# Rezoning Transportation Analysis

Petition Number: #2022-049

Date	Description
08-24-2022	First Review (KP)

**CONCEPT PLAN - L-2**

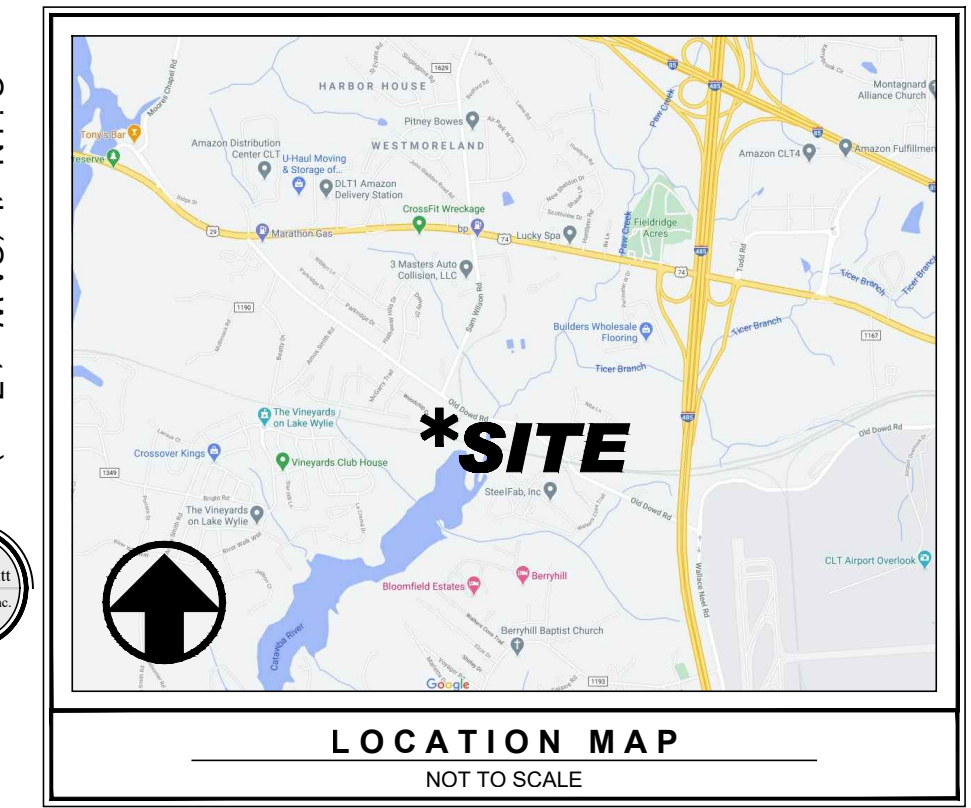
1. Label and dimension the curb and gutter from the existing centerline of Old Dowd Road on the site plan.
2. **Traffic Study:**  
A Traffic Impact Study (TIS) is not necessary for the complete review of this petition due to the site generating less than 2,500 daily trips. If during the permitting process the site generates more than 2,500 daily trips, then a traffic study will be required.

3. Revise site plan and conditional note(s) by labeling and dimensioning the right-of-way along the site's frontage of Old Dowd Road on the site plan. The site plan shall label and dimension the right-of-way from the road centerline.

4. Revise site plan and conditional note(s) to commit to construct an 8-foot planting strip, and 6-foot sidewalk on along the site's frontage of Old Dowd Road. The site plan shall label and dimension both items from the back of curb and gutter.

5. Revise the site plan and conditional notes to commit to provide an 8-foot buffered bike lane along the site's frontage of Old Dowd Road. The site plan shall label and dimension the bike lane.

6. Revise the site plan and conditional notes to commit to provide an eastbound right-turn lane, with 150-feet of storage, on Old Dowd Road at the proposed site access. Additionally, provide a westbound left-turn lane, with 150-feet of storage, on Old Dowd Road at the proposed site access.

7. Revise the site plan and conditional notes to commit to connect the bicycle and pedestrian infrastructure, along the site's frontage of Old Dowd Road, to the adjacent bicycle and pedestrian infrastructure associated with RZP-2021-257.

11. Revise site plan and conditional note(s) to place the proposed pedestrian infrastructure, along the site's frontage of Old Dowd Road, outside of the right-of-way within a public access easement.
